From: Mark Bone [REDACTED]
Sent: 21 April 2015 14:52
To: Daun Johnson
Cc: Ben Poulter
Subject: Re: AL/34/15/HH 6 Elmcroft Place
Attachments: site plan001.pdf

re: 6 Elmcroft Place Westergate PO20 3XL

From: Daun Johnson
[REDACTED]
Sent: Tuesday, April 21, 2015 11:48 AM
Subject: AL/34/15/HH 6 Elmcroft Place

site plan

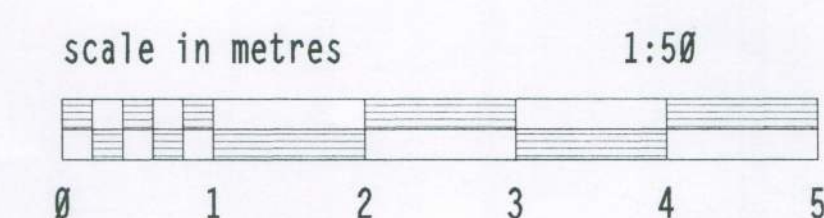
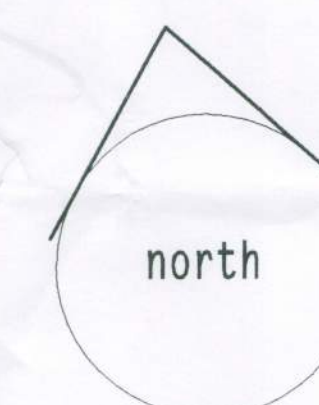
I refer to this email and the following mail requesting a site plan at a scale of 1:500/1:200 including measurements from the proposal to the site boundaries.

The submitted drawings include a site plan at a scale of 1:200. Please find attached an amended site plan revised to include the measurements requested.
